Department of Planning, Industry & Environment

Notice Number **1593218**

Date **1 April 2020**

RE: Proposed Expansion of the Enviro Waste Services Group Yennora Liquid Waste Treatment Plant

Figure 3-1: Proposed floor plan for 14 Kiara Crescent

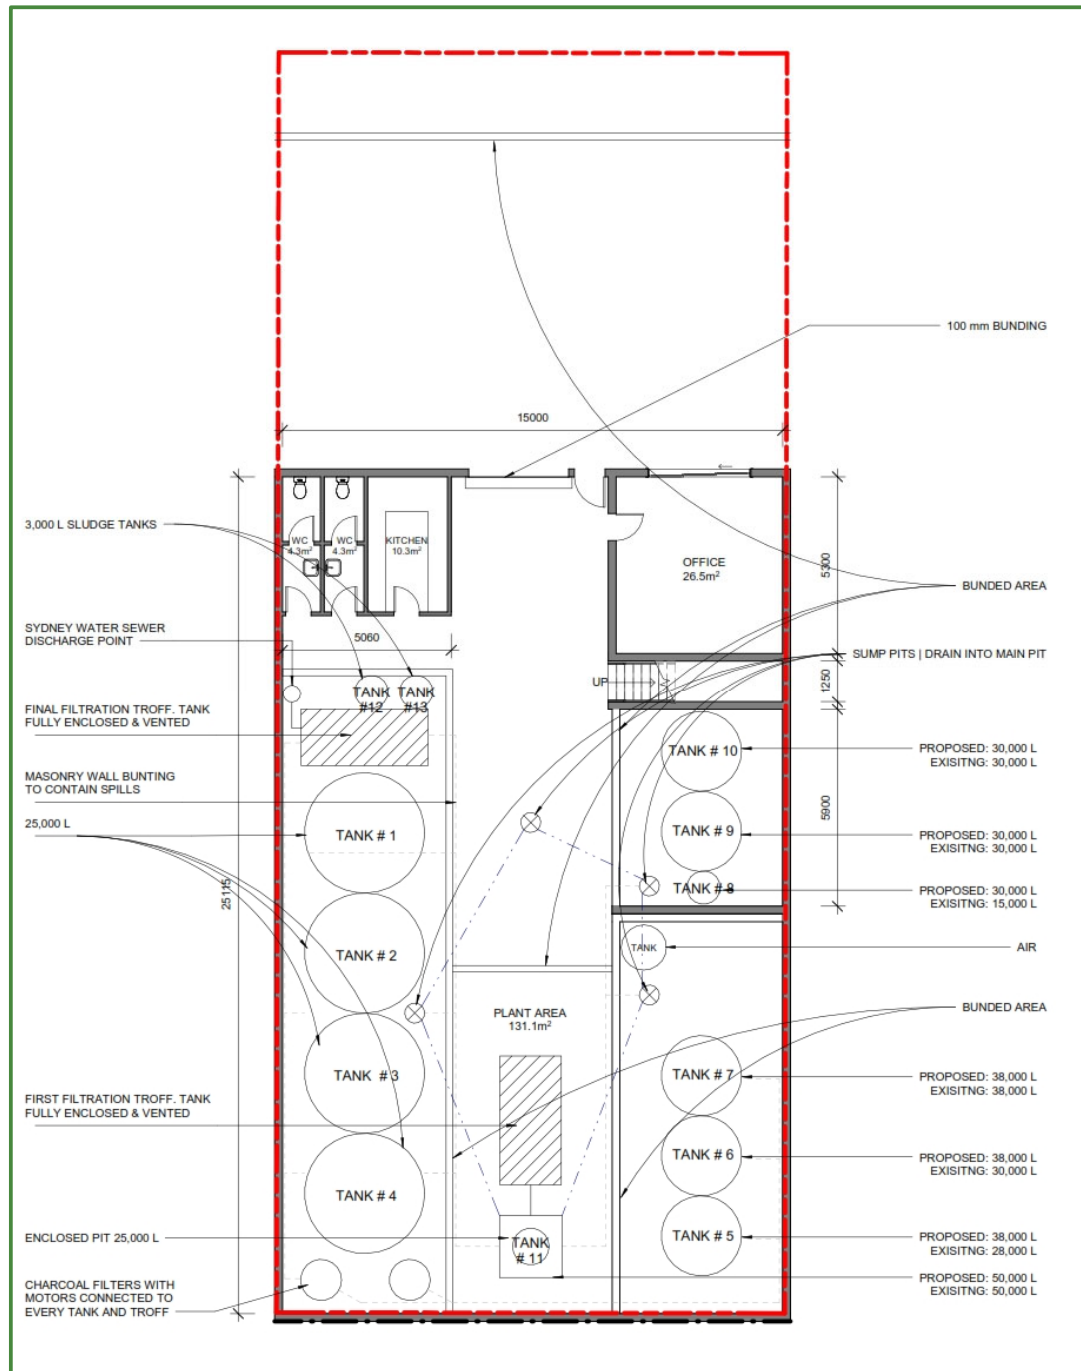
1. Clarity on the volumes of each waste type, the manner in which each waste type will be received and stored at the premises, and individual storage tank capacities (existing and proposed).

2. Explanation as to how existing equipment onsite would be able to achieve a 111x increase in annual production, noting that this appears extreme even with extended operating hours.
